This is the Written Representation of Mrs Jane Shearer, registered Interested Party, in respect of the East Pye Solar Project (EN0110014). This document supersedes and replaces an earlier version submitted in September 2026. The representation objects to the inclusion of Site 8 (Sub-Sites 8A and 8B) in the Order Limits on grounds of severe harm to the Hawes Green heritage cluster within the Shotesham Conservation Area, material methodological failures in the Landscape and Visual Impact Assessment and Residential Visual Amenity Assessment, two material factual errors in the visual baseline (ES Appendix 7.4), and inadequate mitigation. The full grounds are set out in the attached document.

East Pye Solar — Planning Inspectorate Reference EN0110014

Subject: Formal Written Representation — Objection to East Pye Solar Project (EN0110014): Severe Harm to the Historic Setting and Immediate Approach of the Hawes Green Heritage Cluster; Material Methodological Failures including Flawed RVAA Methodology; Factual Errors in the Visual Baseline; and Inadequate Mitigation (Site 8)

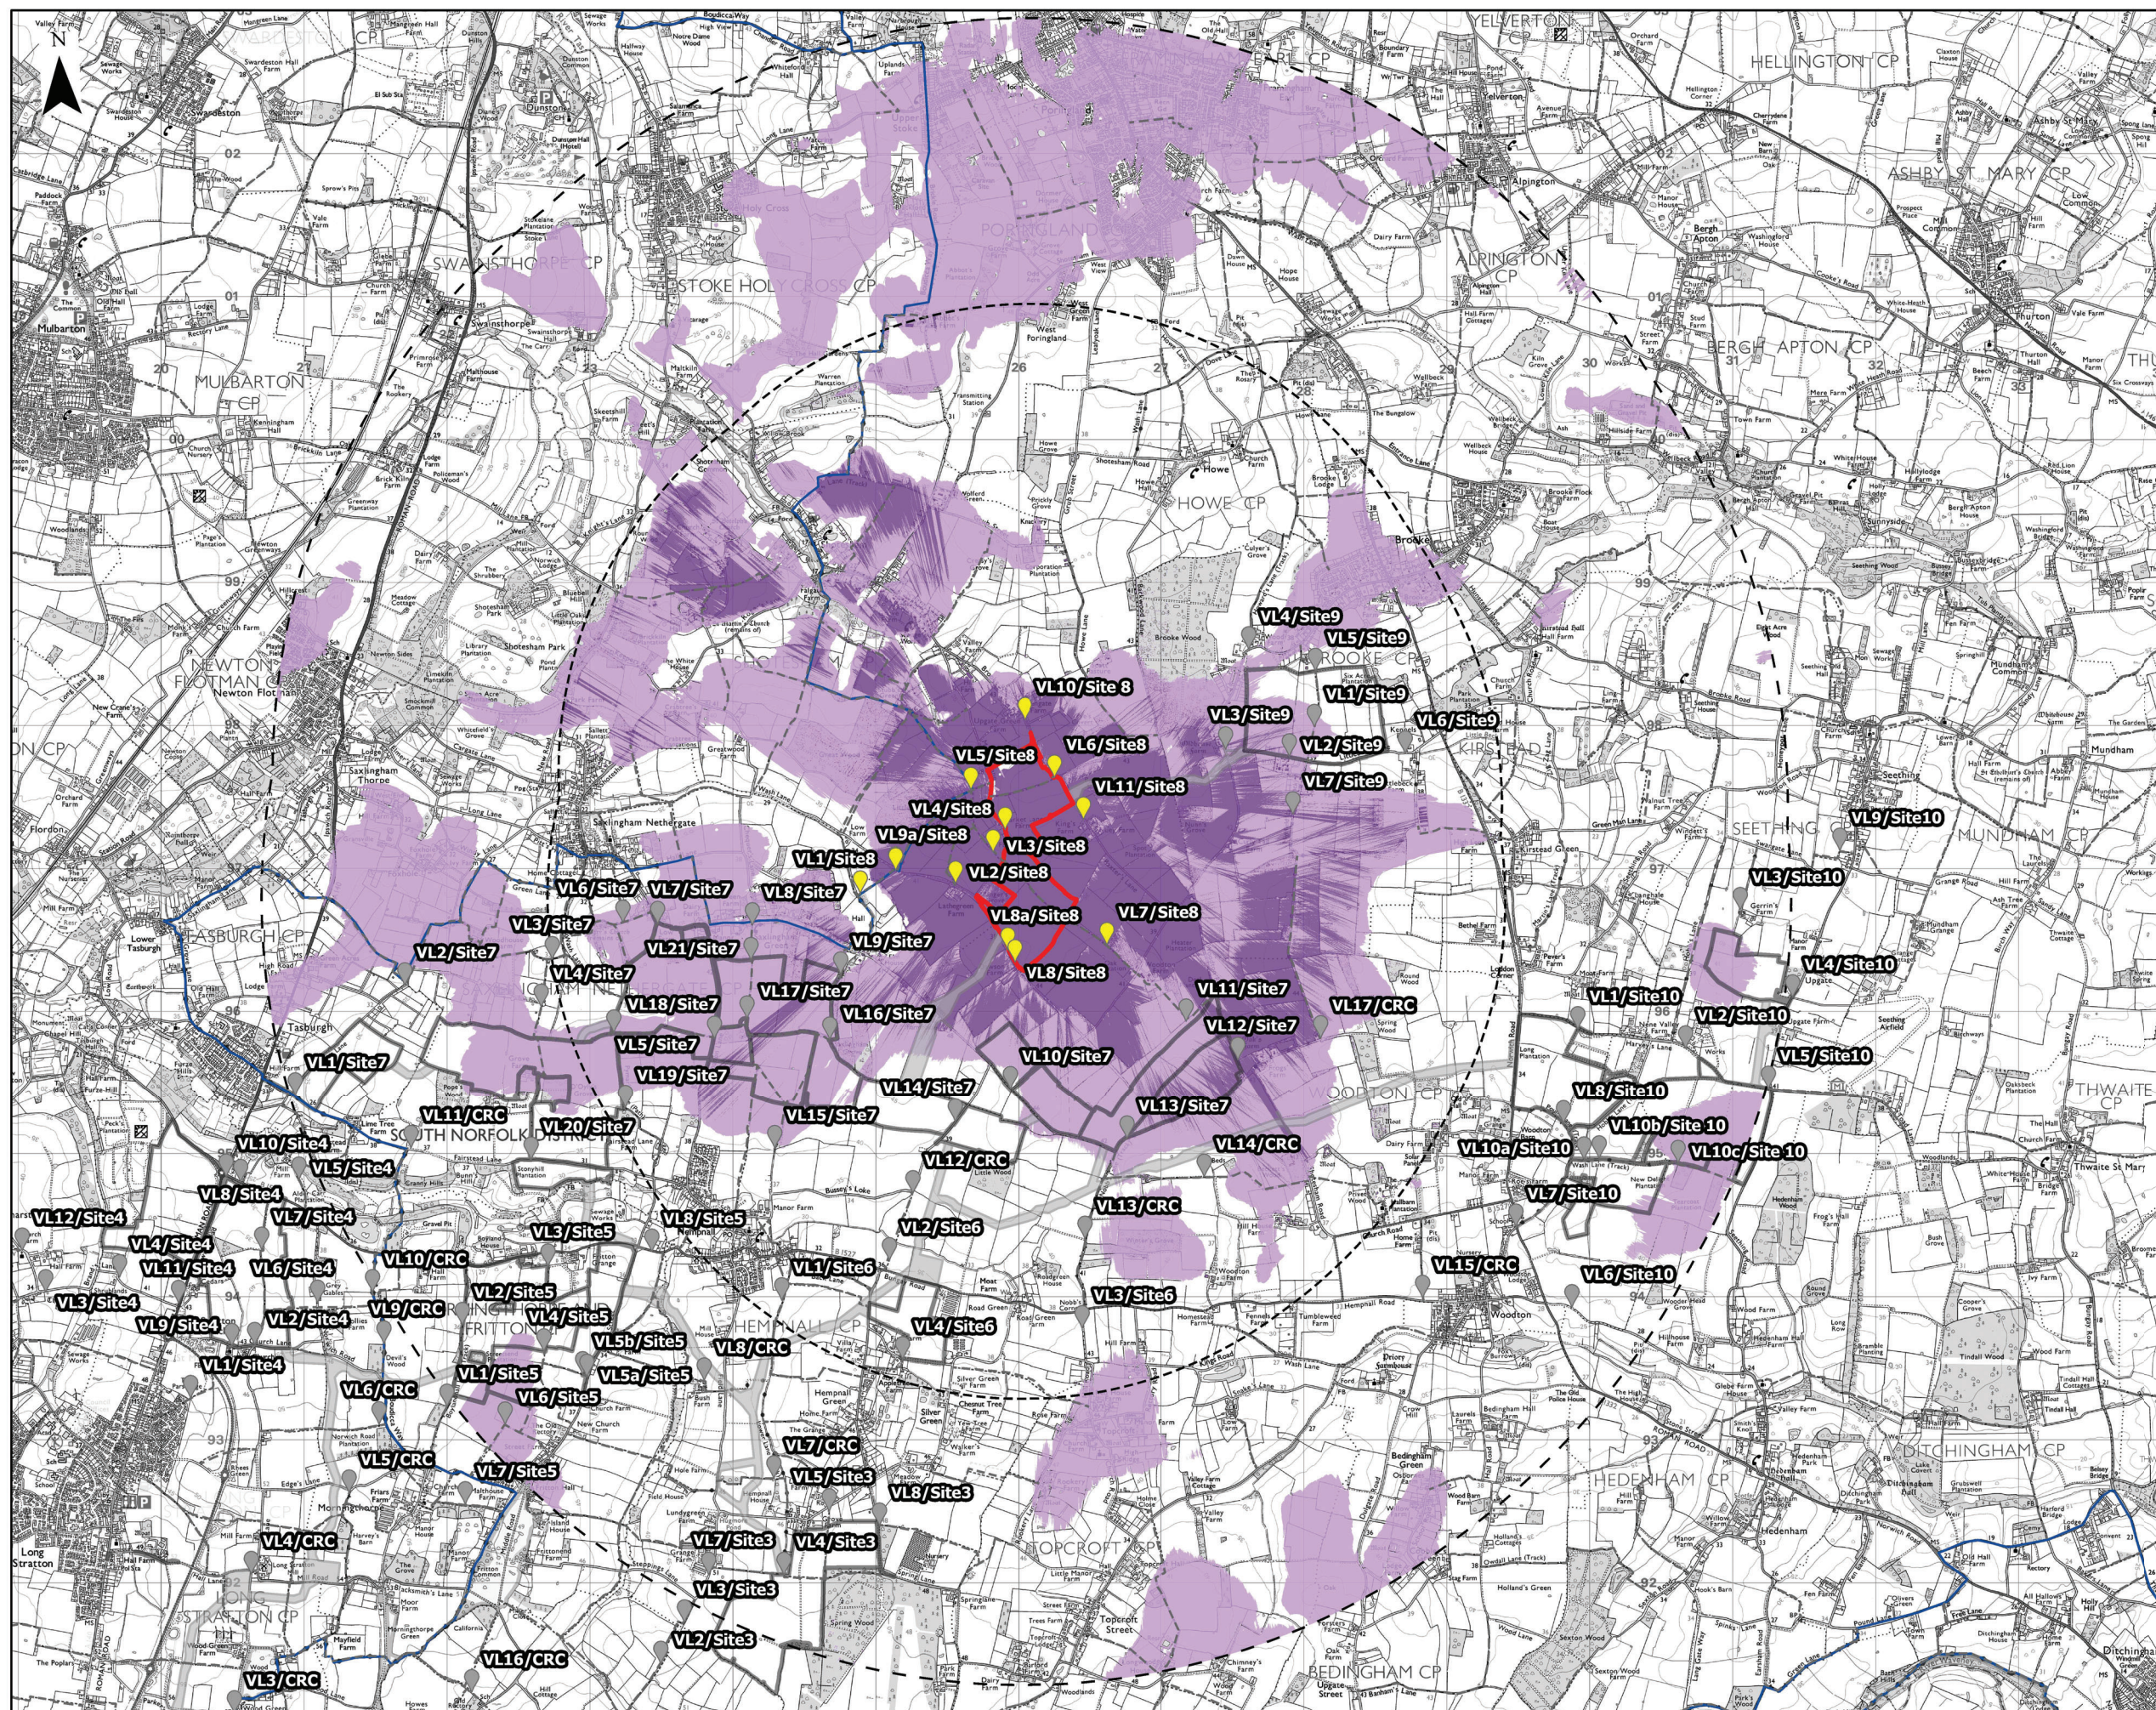
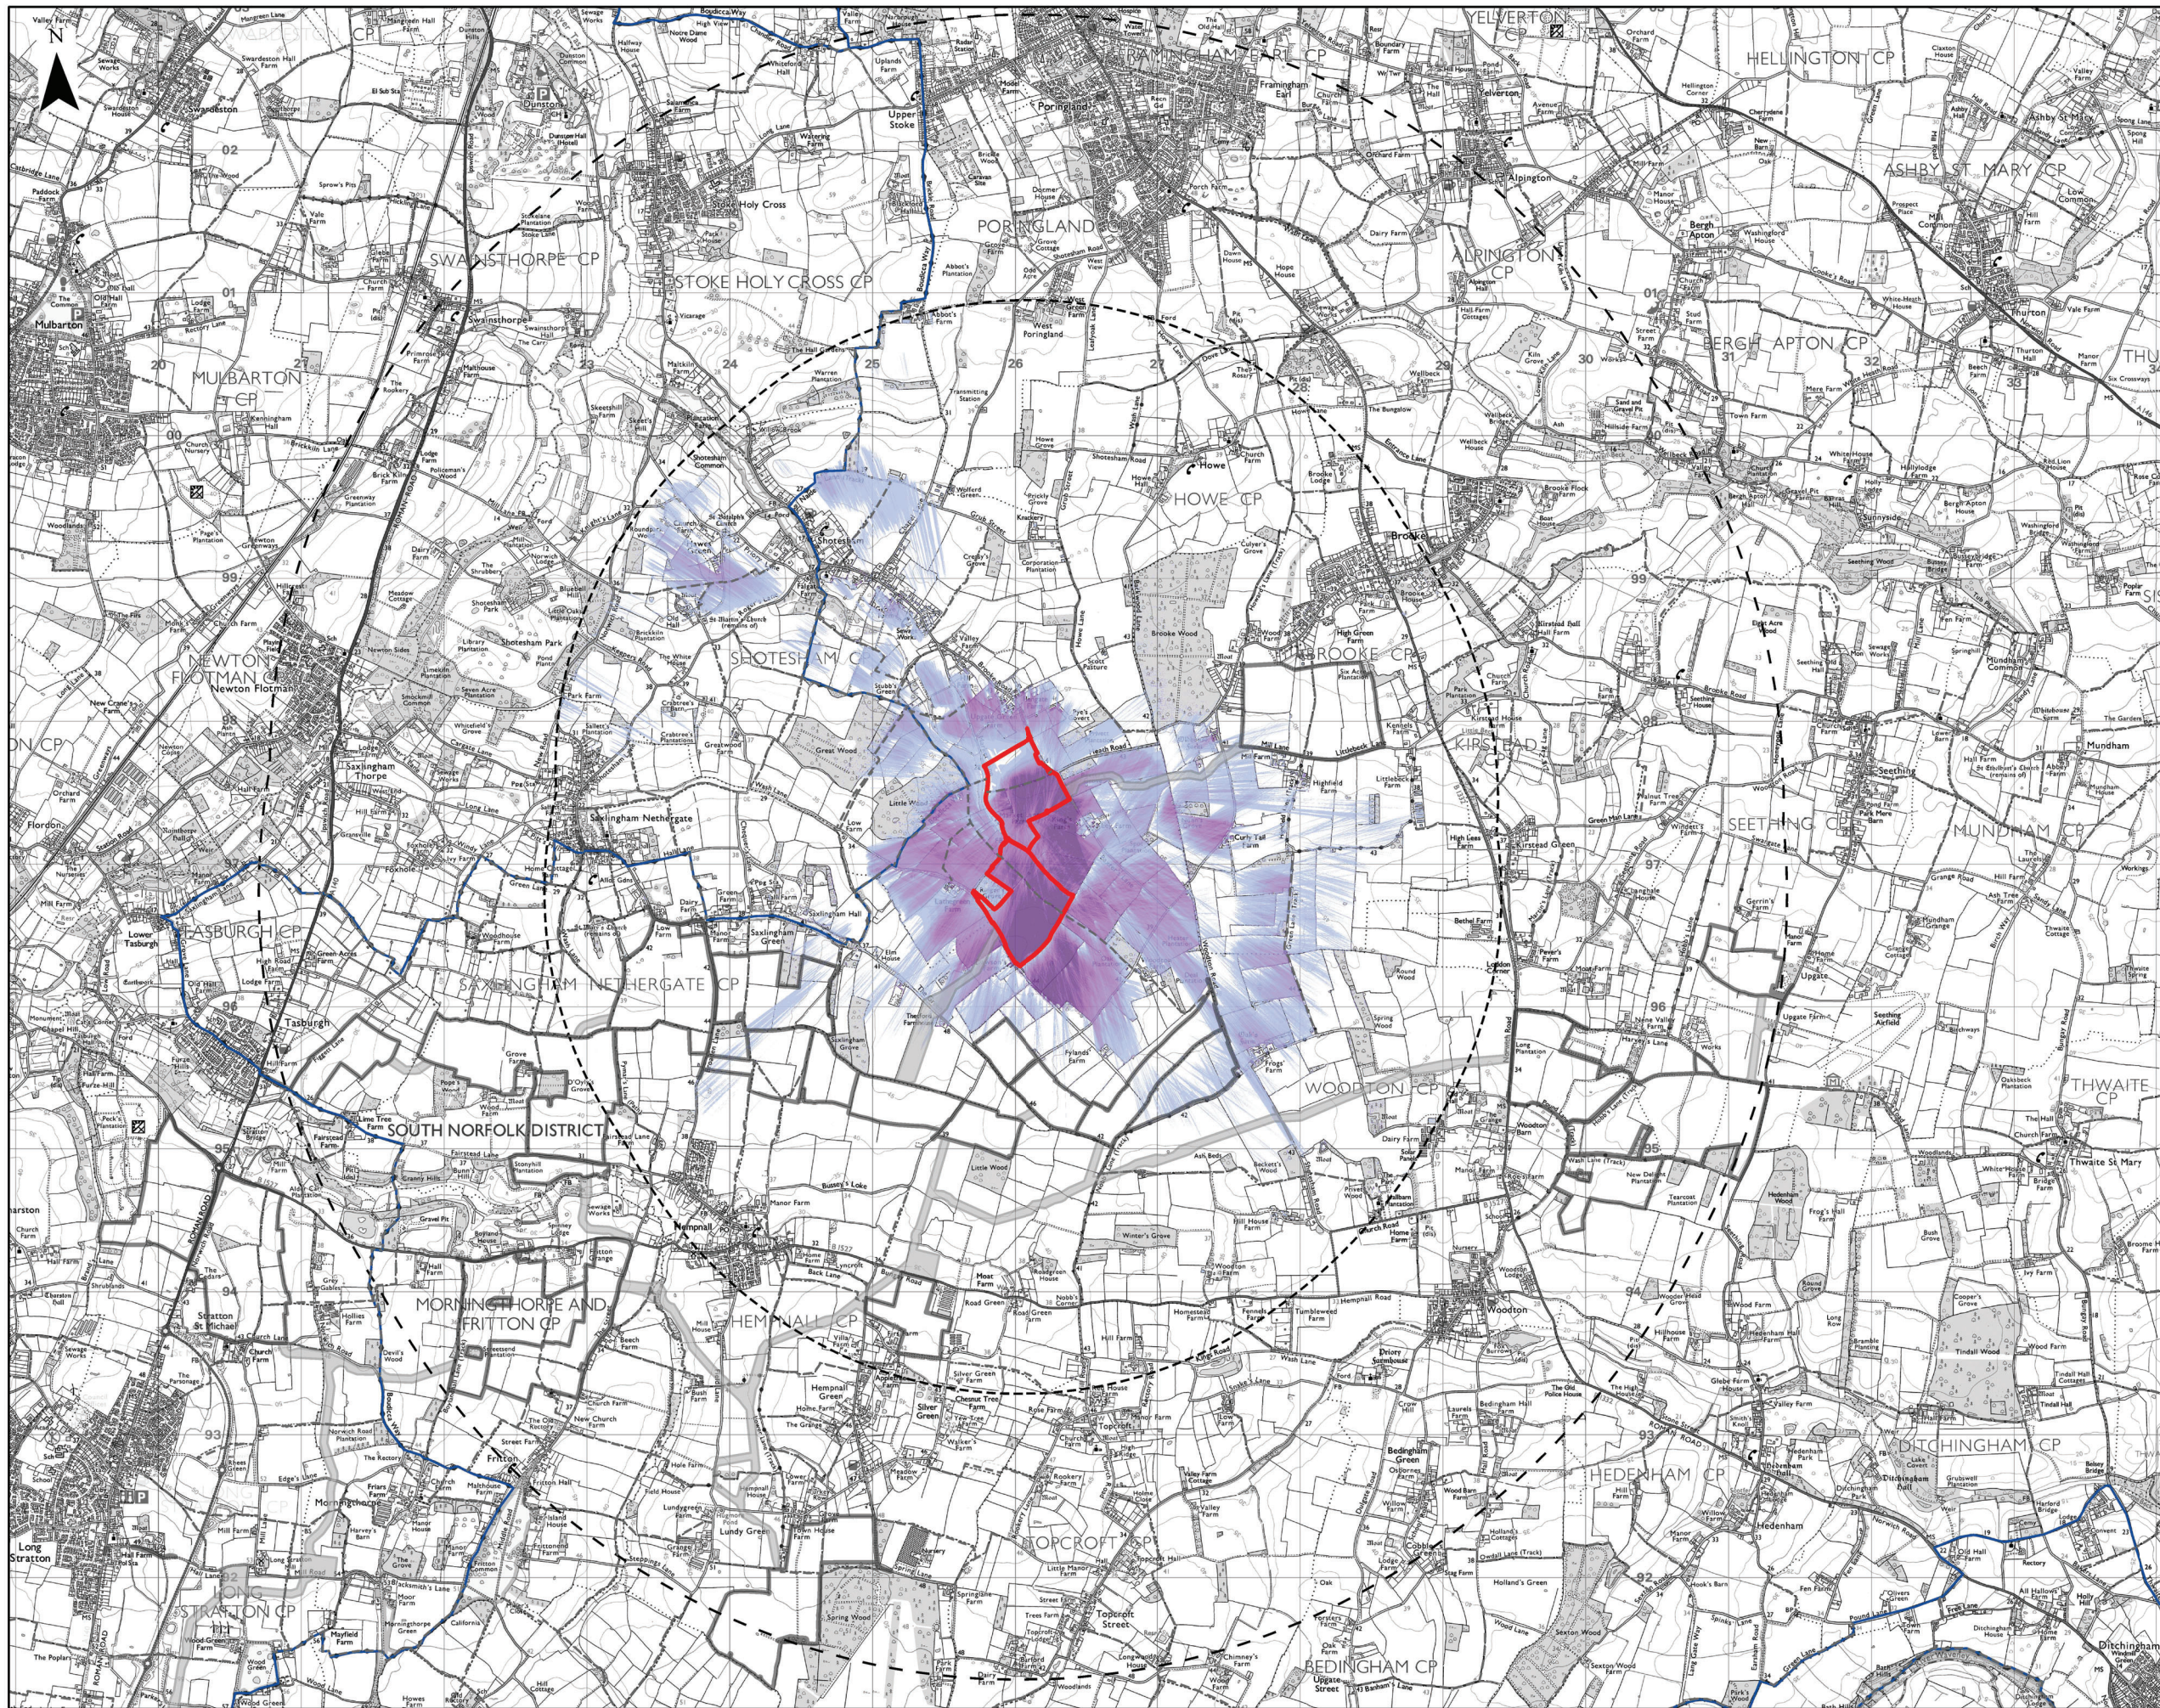
- (c).** Requires the Applicant to confirm whether Hawes Green falls within the ZTV for Site 8 (Figure 7.5.4) and, if so, to explain why neither the LVIA nor the RVAA has assessed the visual impact on this location, given that ES Chapter 7 paragraph 7.5.22 acknowledges Shotesham as a settlement from which visual effects are likely;
